Our Ref: ID 3576
Your Ref: SSD-83258708

State Significant Development Application for EIS Florida Street, Sylvania, Affordable Housing SSD-83258708

Thank you for the opportunity to provide advice on the State Significant Development Application for 29 Florida Street, Sylvania. It is understood that the proposed development undertaken by Homes NSW consists of both social and market housing and seeks to construct eight residential buildings with a total of 484 dwellings, completed in 2 stages comprising:

Map 1 - 20% AEP - Existing Scenario - Flood Depth

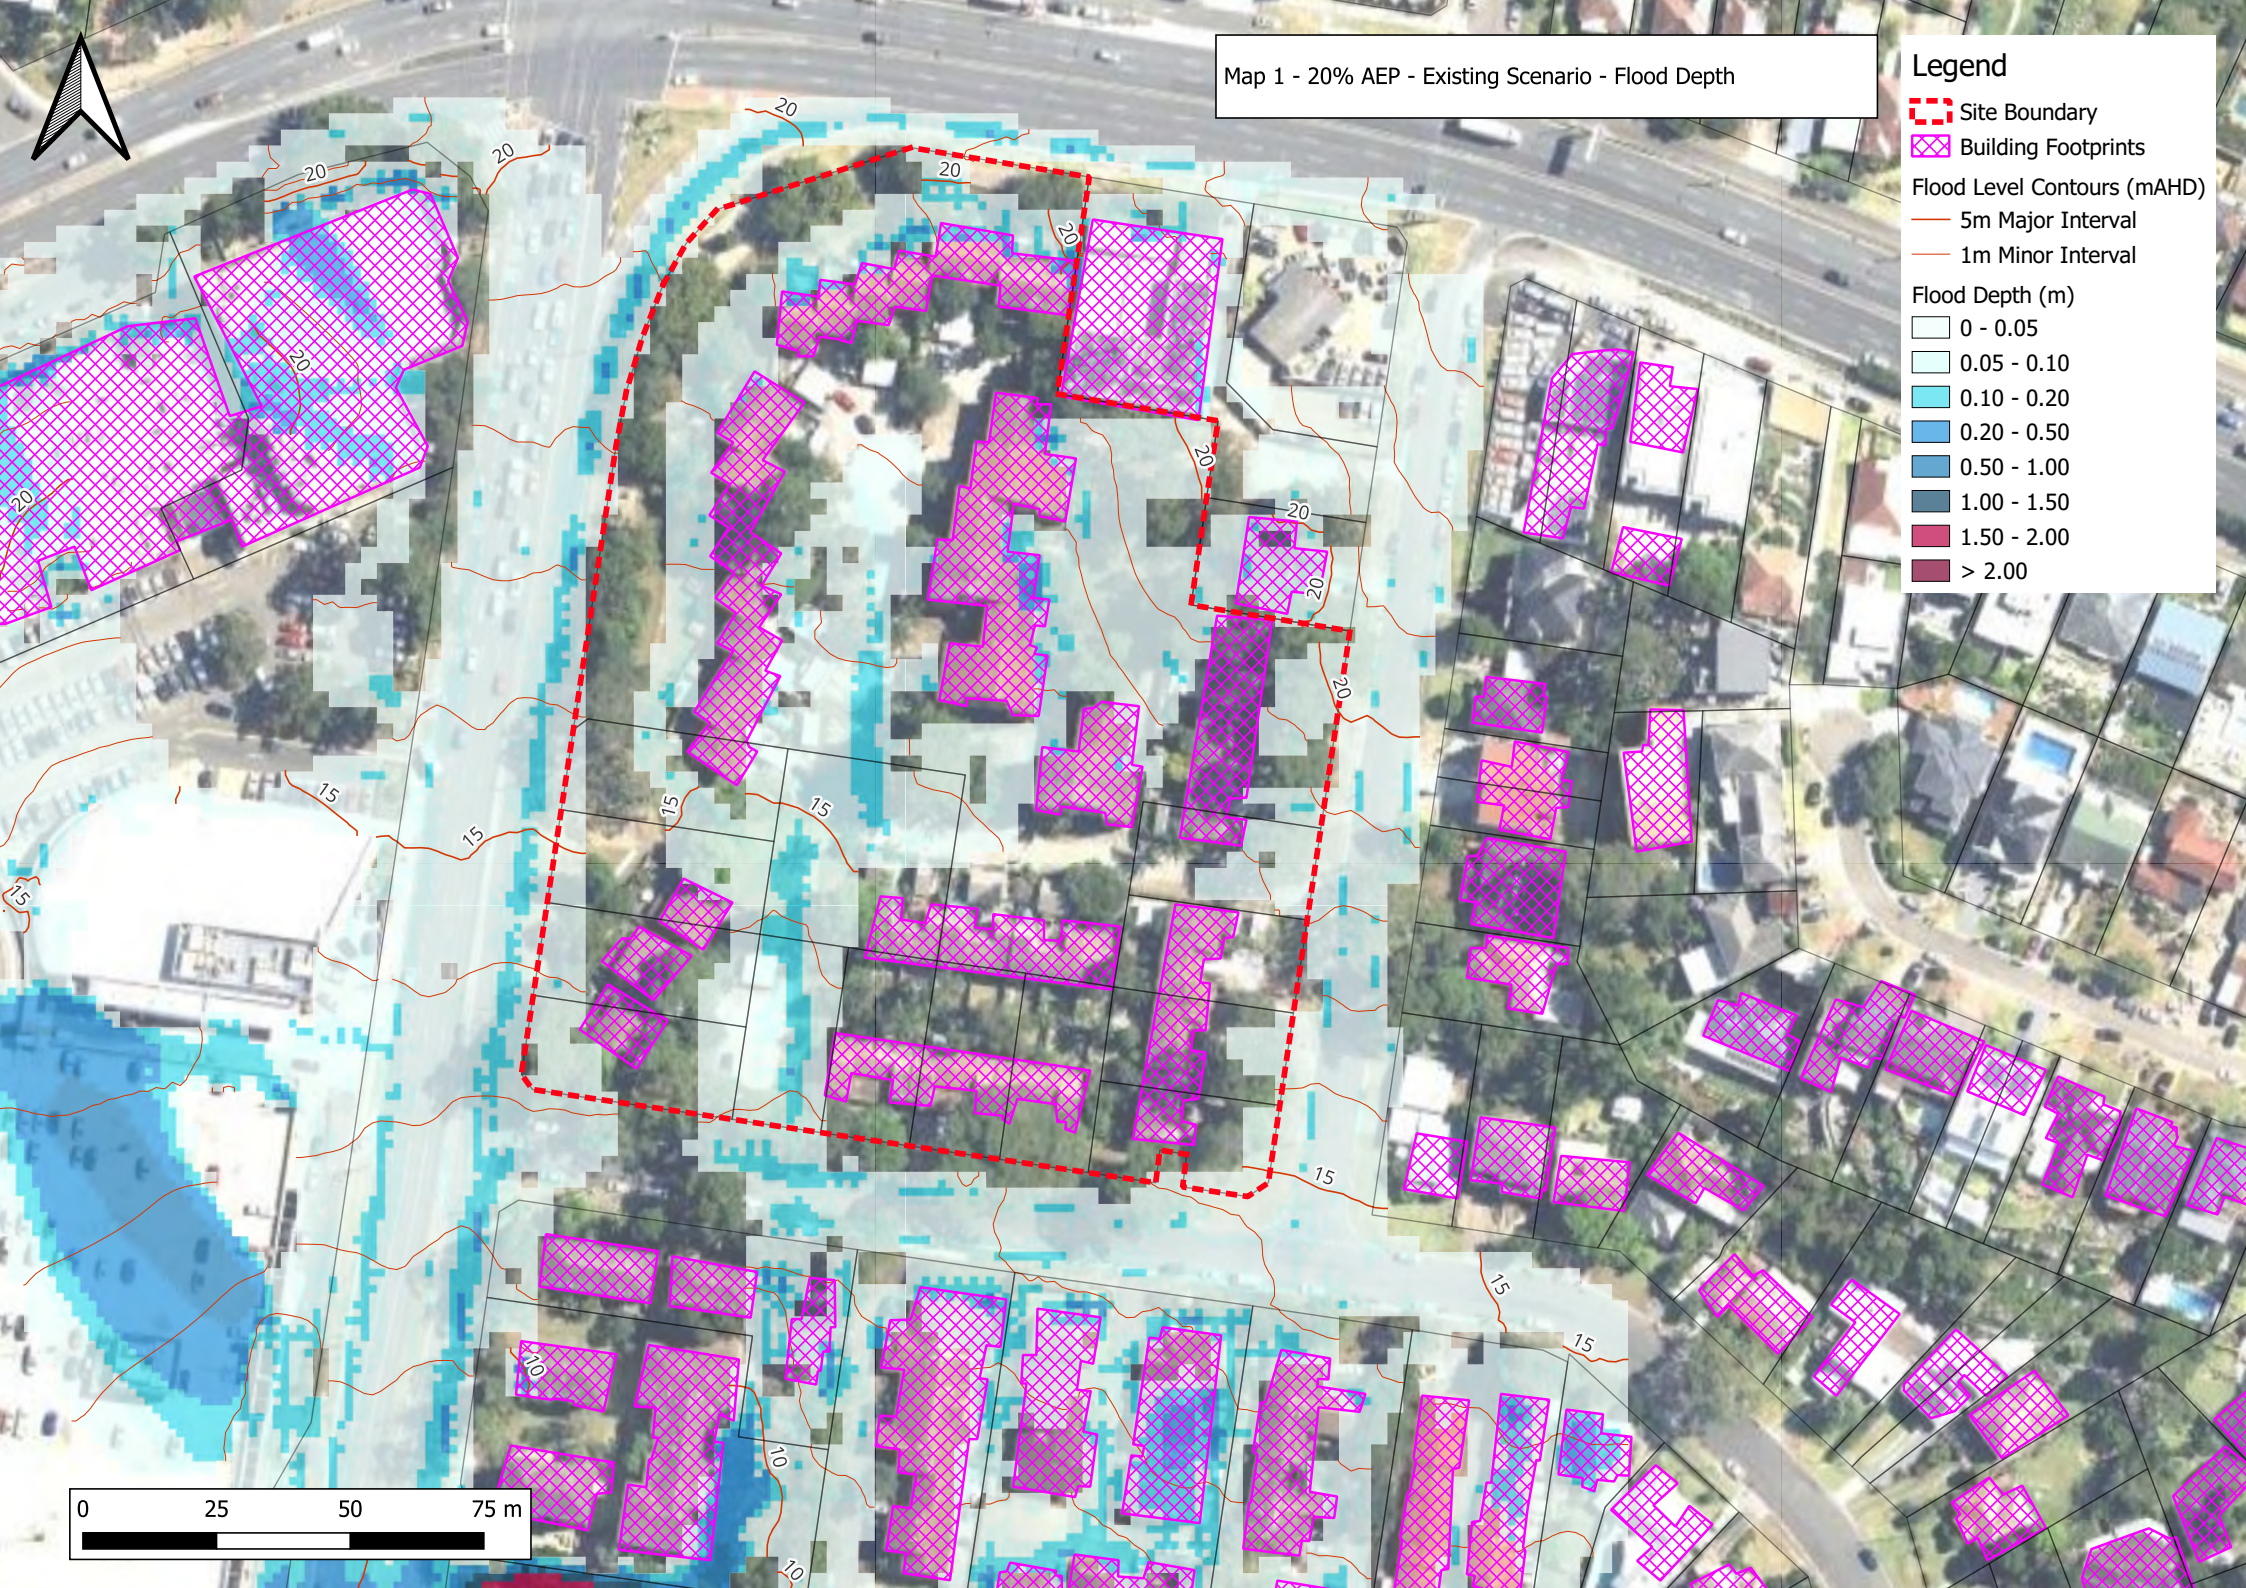
The site is affected by shallow overland flow as frequently as the 20% Annual Exceedance Probability (AEP) event.¹ During the PMF event, under current conditions, the site is largely inundated reaching depths of up to 0.5 metres² and Hazard Level 2 (H2).³ The level of hazard on roads surrounding the site is significantly higher, reaching H5. This level of hazard is unsafe for all people and vehicles with buildings requiring special engineering design and construction.

The site is affected by shallow overland flow as frequently as the 20% AEP event reaching depths of up to 0.2 metres within the site.¹⁰ During the PMF event, under current conditions, the site is largely inundated reaching depths of up to 0.5 metres¹¹ and Hazard Level 2 (H2).¹² The level of hazard on roads surrounding the site is significantly higher, reaching H5. This level of hazard is unsafe for all people and vehicles with buildings requiring special engineering design and construction.

Map 6 - 1% AEP - Existing Scenario - Flood Hazard

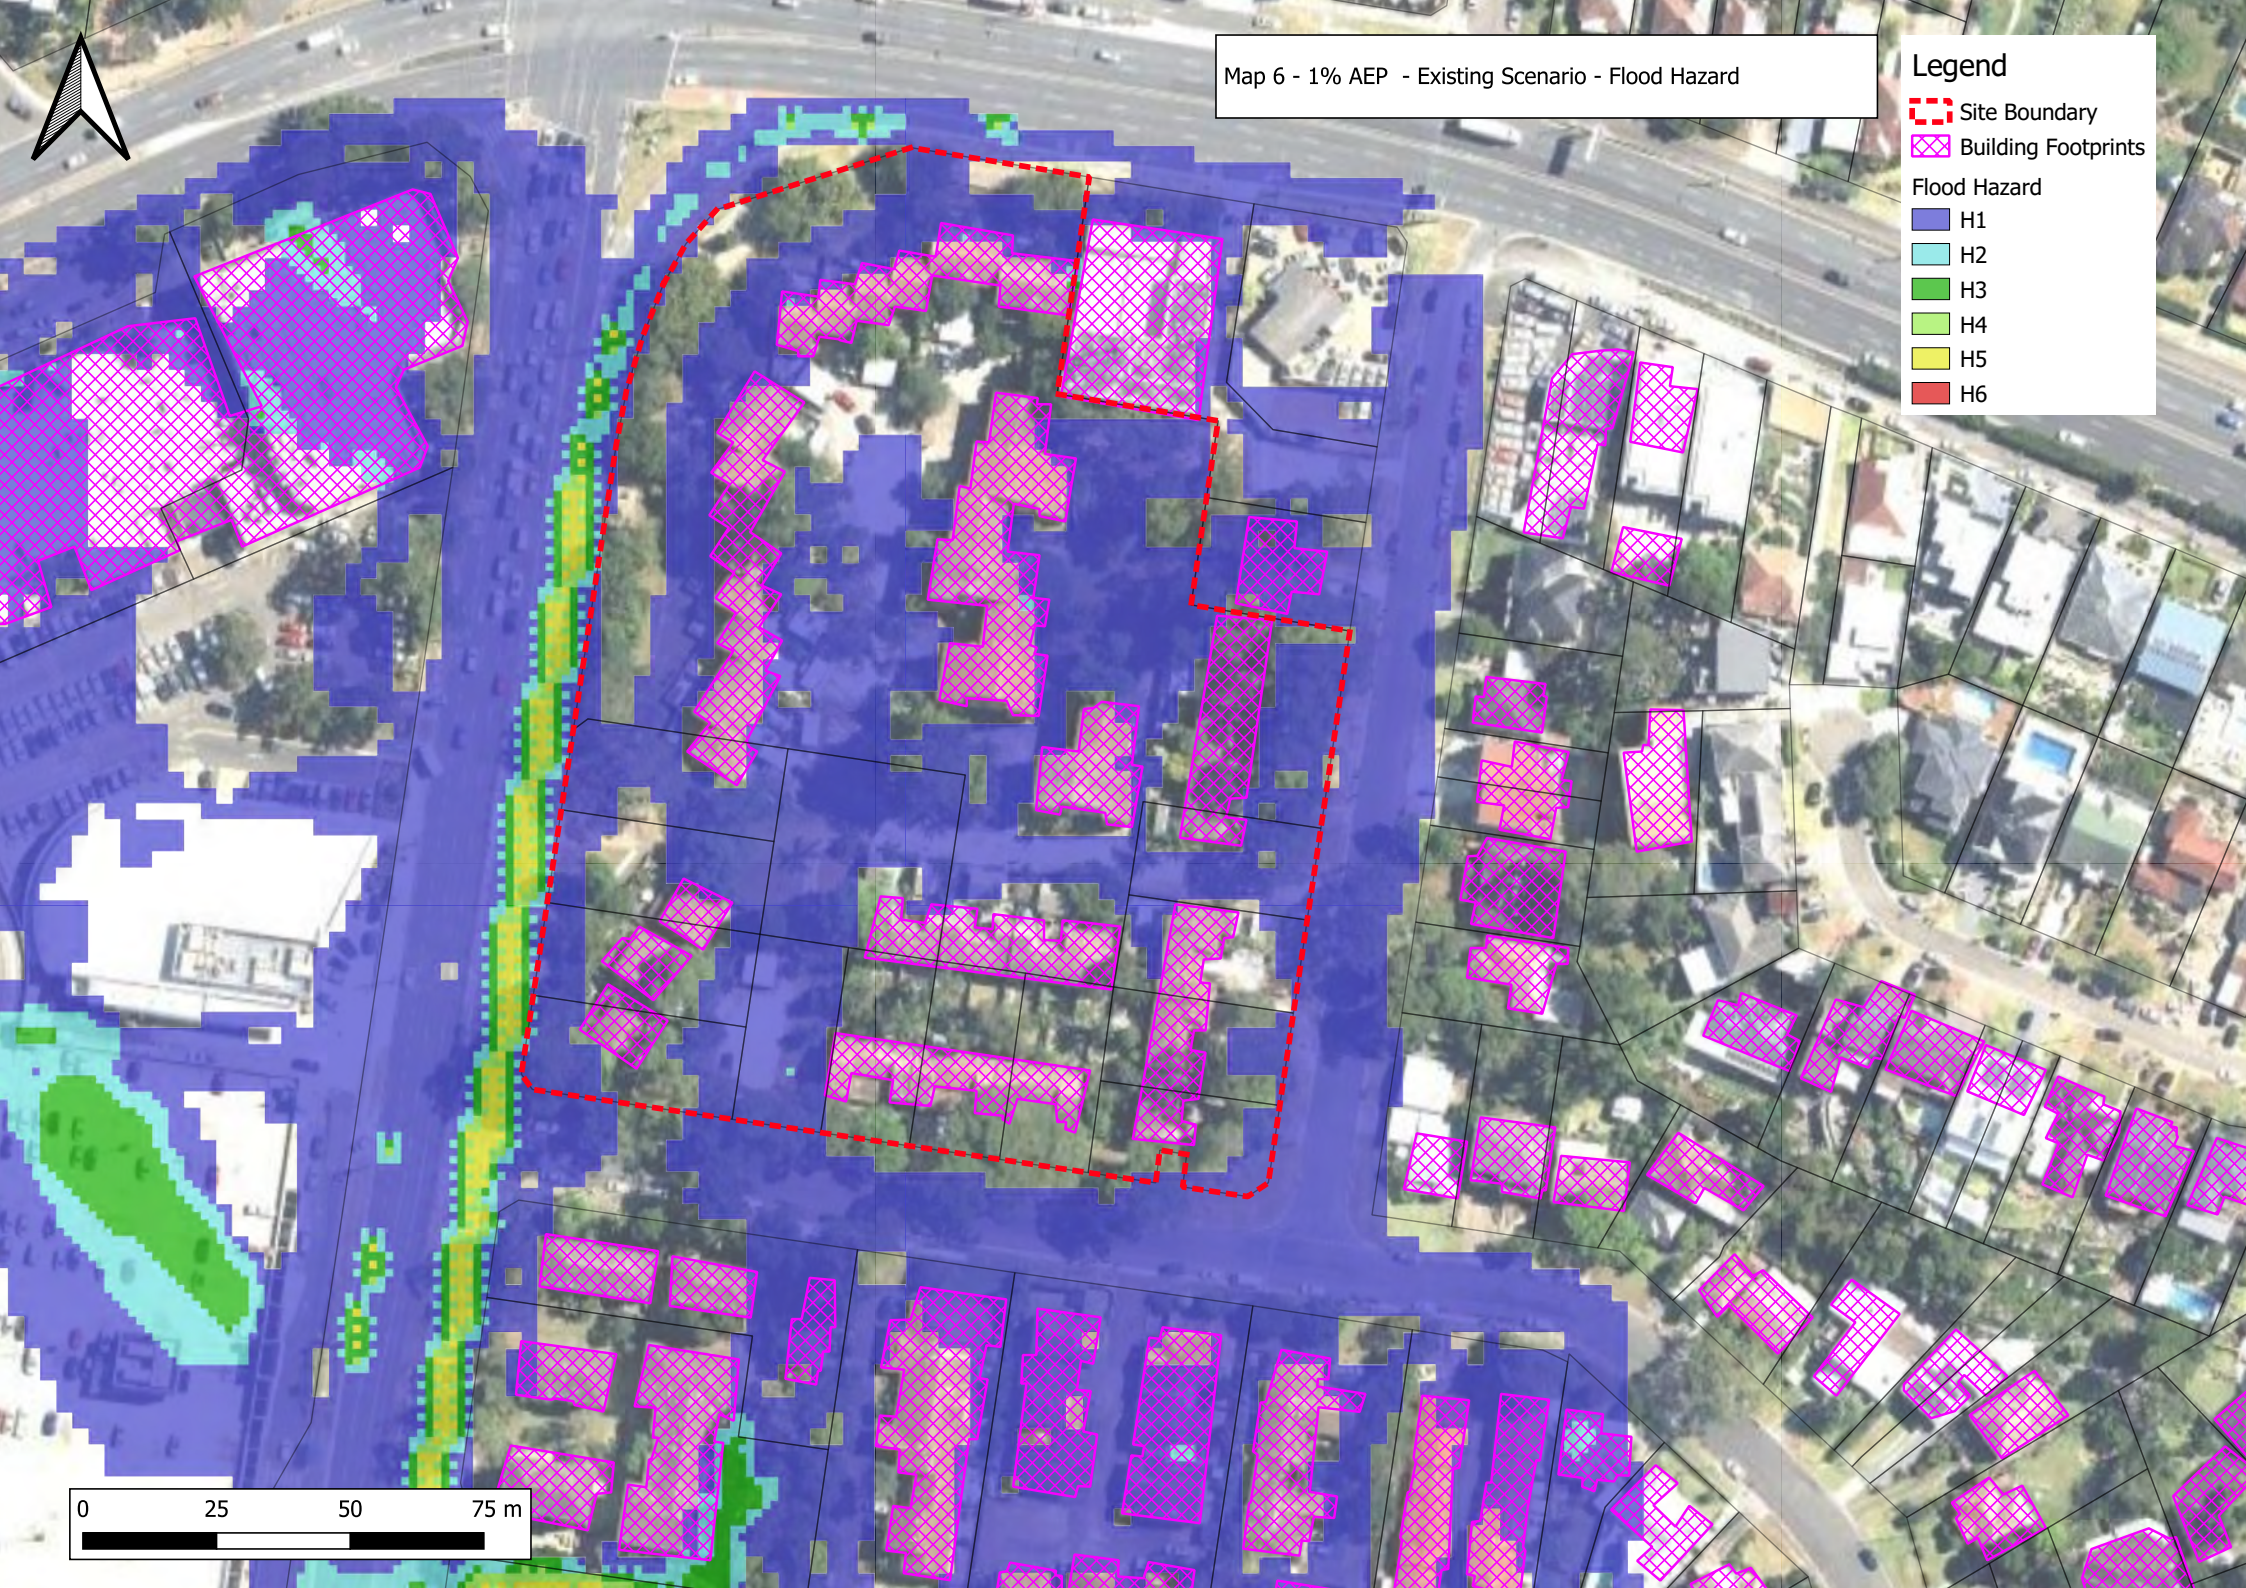
The proposed design increases flood hazard within the site posing a risk to life to site users. By including the proposed mitigation measure of *“the channelisation of overland flows within the Site to the internal roadway”*¹³ the hazard within the site itself is increased. During flood events up to and including the 1% AEP flood the hazard is increased from H1,¹⁴ which is generally considered safe, to contain *“A peak flood hazard of H5 within the internal proposed roadway.”*¹⁵ This level of hazard is unsafe for all people and vehicles with buildings requiring
